Public Rights of Way (“PROW”) consultation

Planning application: 2017/62/92986/W

Address: land at, Deer Hill End Road, Meltham, Holmfirth, HD9 5PS

Proposal: Erection of agricultural worker's dwelling

J M & V J Howard
Proposed Agricultural Worker's Dwelling at Deer Hill End Farm, Meltham
Block Plan 1:500 @ A4 July 2017

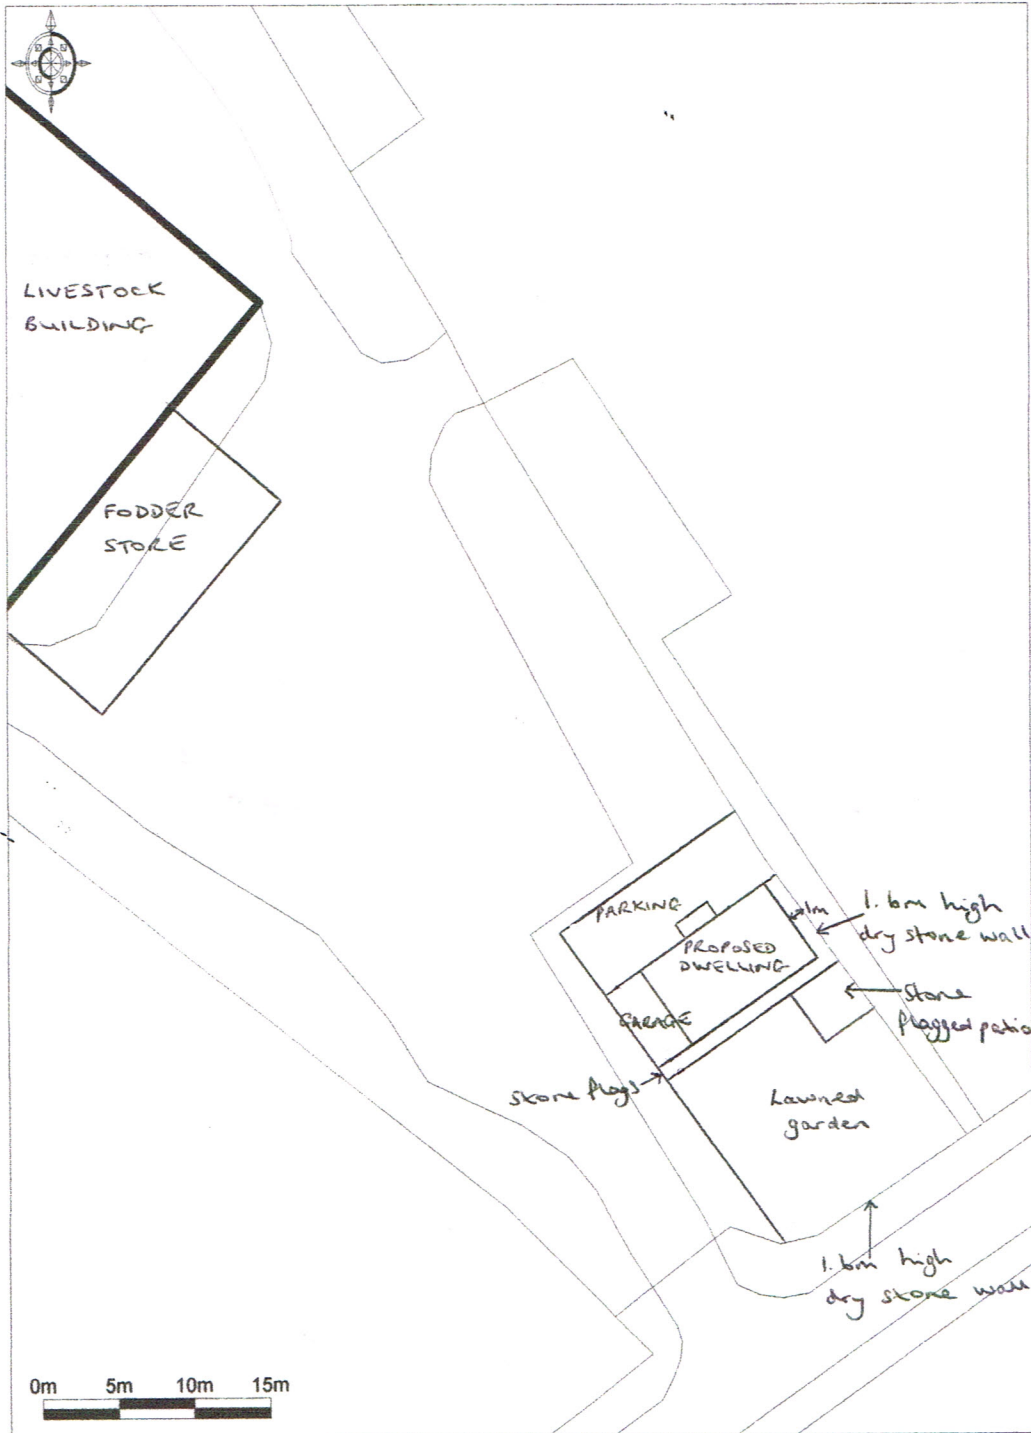
The application submissions do not show, mention or recognise the public bridleway, over which access to the proposed development is identified. Intensification of vehicular use of the public bridleway is not supported.

A scheme for the protection, during the development, of both the public bridleway and the public using the public bridleway, should be required by condition. This condition should include and require provision, agreement, implementation and retention of the scheme. This may include, signing, guarding, loading/unloading areas, operational practices, route surveys, ongoing repair and maintenance etc.
